MMC Trip Distribution

Fri, Apr 27, 2018 at 12:38 PM

We have had a chance to take a look at the trip distribution. Here are our comments:

Potential St. John Street Parking Garage Trip Assignment

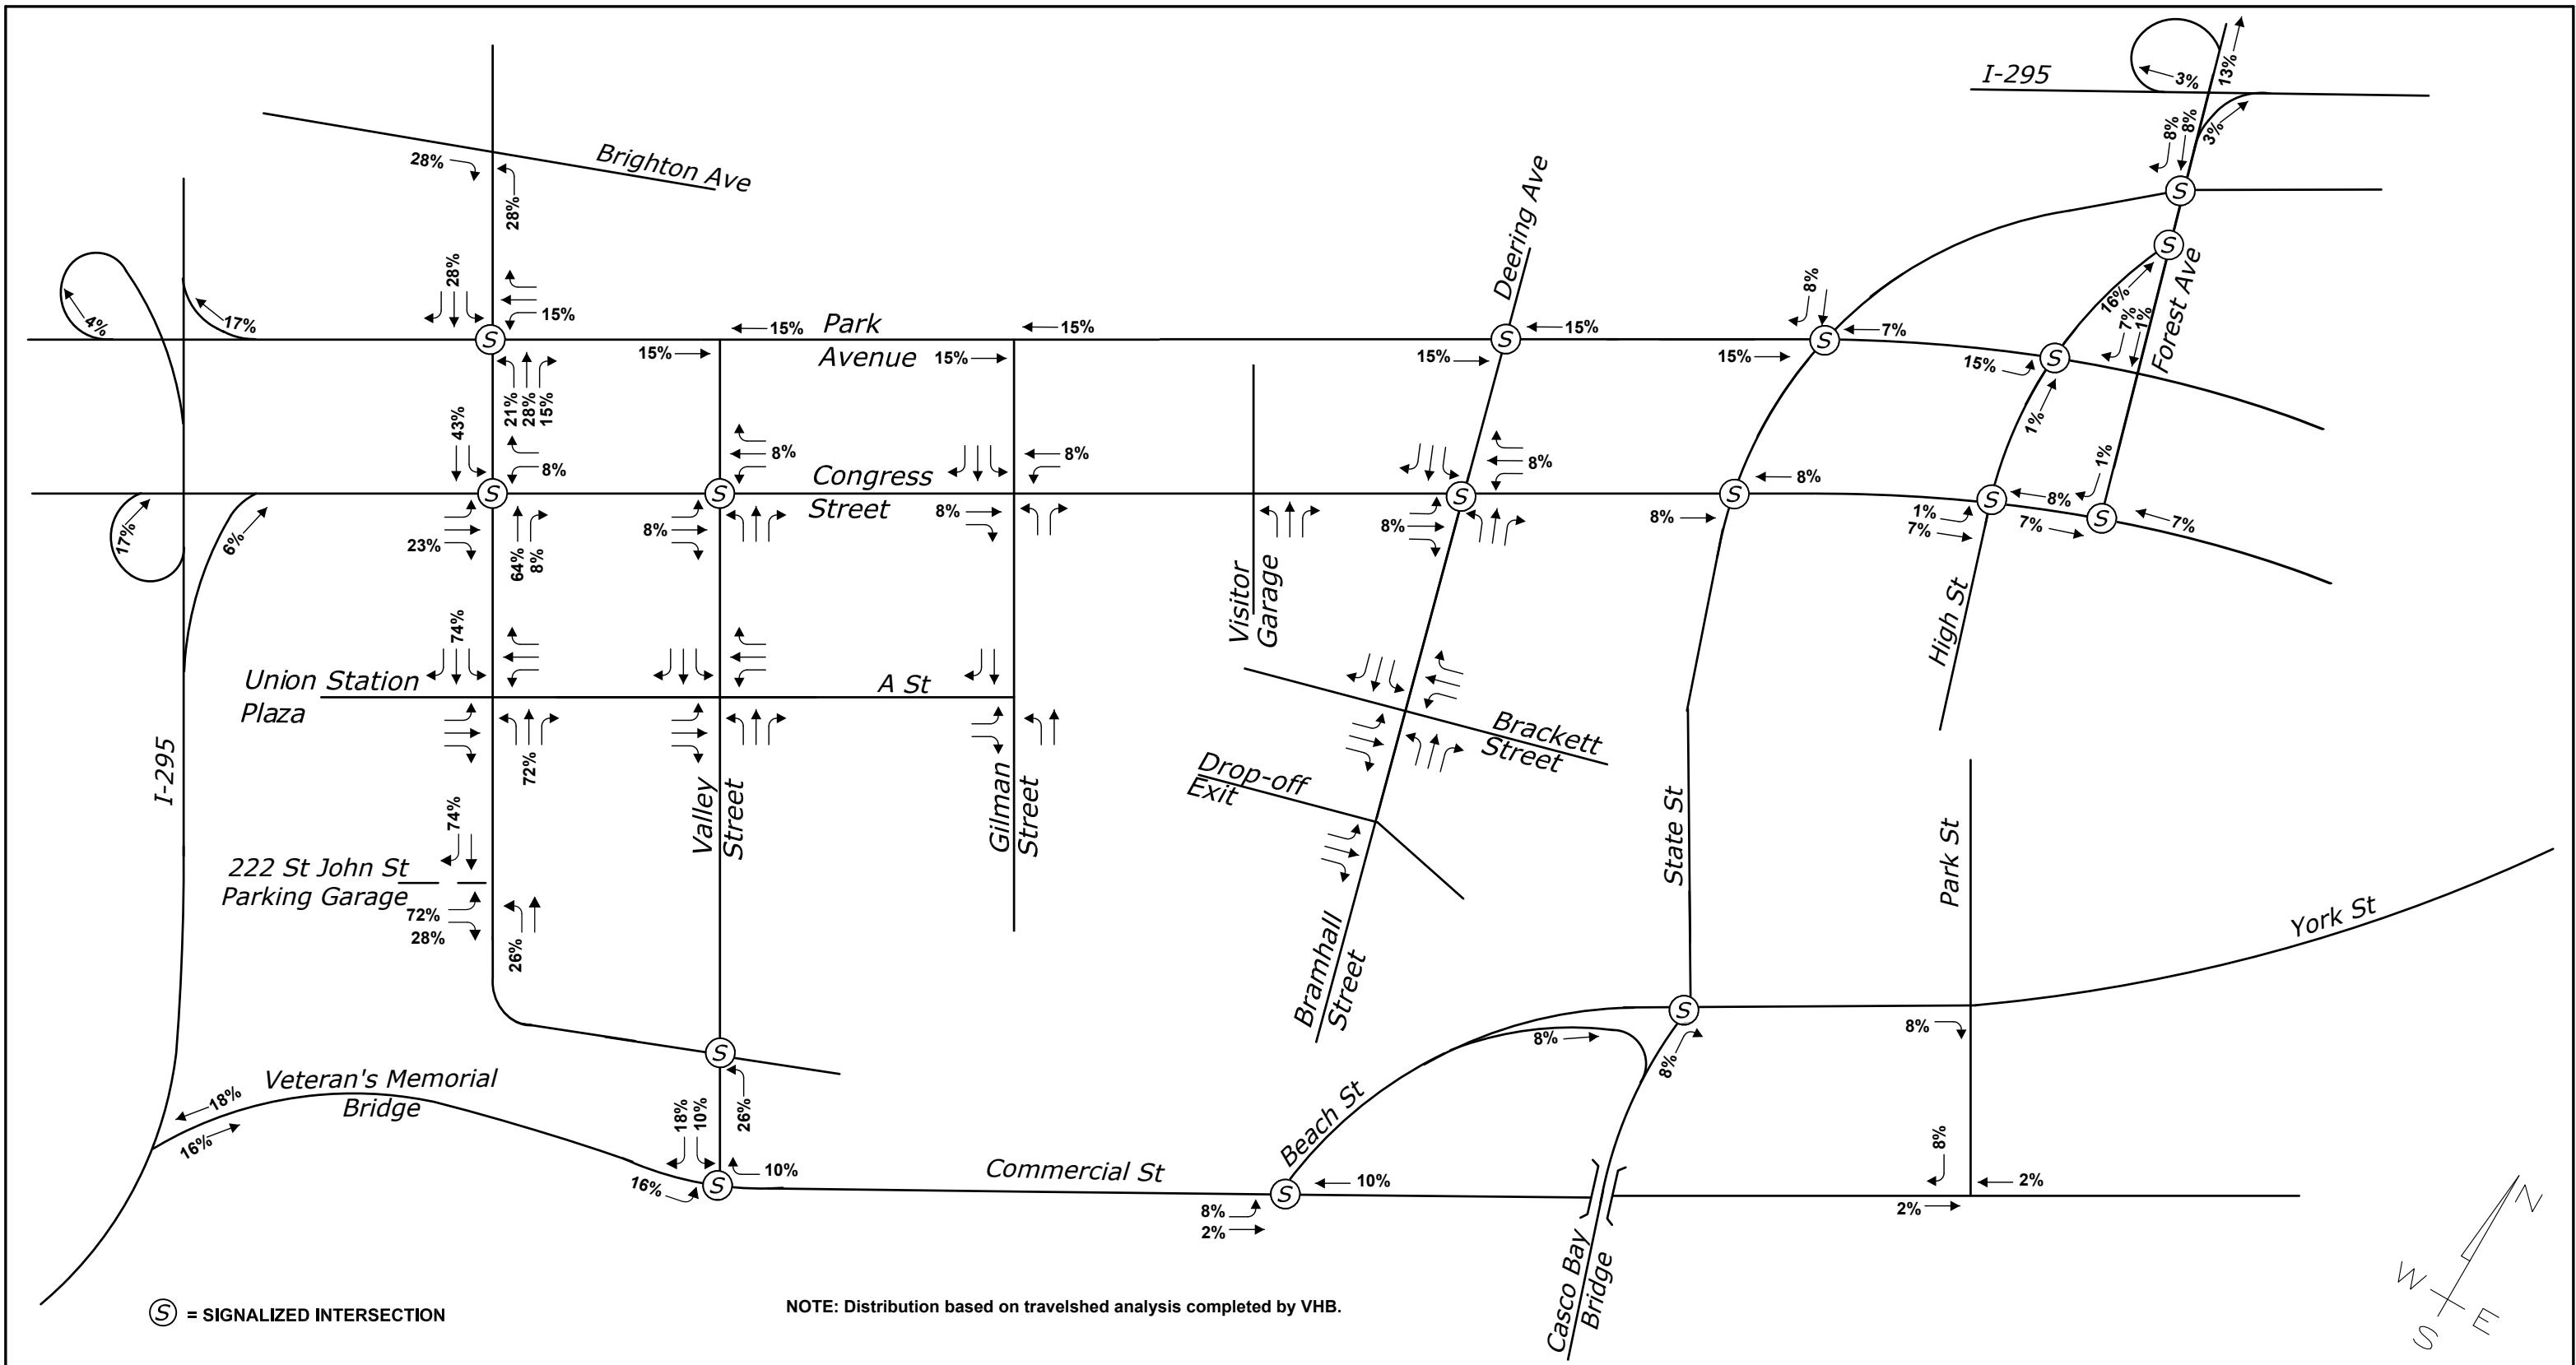
1. Can you provide an explanation as to whether/how VHB calibrated the travelsheds with actual employee travel surveys?
2. The percentages for trip assignment based on the travel sheds would appear to generally make sense, although they are likely somewhat conservative for the major in-town routes, as travelers will use any number of methods to accomplish what they feel is an optimal travel pattern. Can you speak to this concern?

3. There are no MMC trips assigned to Outer Congress Street. Some MMC traffic should be assigned to Outer Congress Street, or documentation on why it is not expected should be provided.

4. The regional assignment of trips closely matches the VHB Employee Travelshed analysis with the following conclusions:
 - a. 17% of the trips are from I-95 (from the south). **[VHB estimated 17%]**

- b. 13% of South Portland area (Knightville/Cape Elizabeth) trips are split between 8% via Casco Bay Bridge and 5% via Exit 4 and VMB. **[VHB estimated 13%]**

- c. Of the I-295 NB trips from the south most will use VMB (16% in AM) with 6% (AM) using Congress Street (Exit 5). In the PM it is 18% using VMB and 4% using Exit 5.

- d. 20% of the trips will be destined to I-295 north of Forest Avenue with 17% using Park Avenue to the Exit 5 on-ramp and 3% using St. John Street/Park Avenue/High Street to Exit 6 on-ramp. **[VHB estimated 12% for I-295 north of Portland. It is unclear if trips are getting off Franklin or Washington – possibly to I-95NB].**

- e. 28% of the trips are assigned to Brighton Avenue. **[VHB estimated 25%].**
 - f. 13% of the trips are assigned to Route 302 north of I-295. These trips originate from Park Avenue. **[VHB estimated 13%]**

- g. 9% of the trips are assigned to the Peninsula with 2% via Commercial Street and 7% via Congress Street. **[VHB estimated 9%]**

Based upon the above, we would suggest that the two sets of information be merged in the development of a final assignment. In general, the VHB regional travelshed methodology seems reasonable. What is not clear is how motorists will route to the travelshed areas, particularly in the vicinity of MMC. Some notable discrepancies:

- Congress Street inbound from the west approaching St. John – 23% vs. 46%
- Brighton Avenue – 28% vs. 17% in AM and 15% in PM
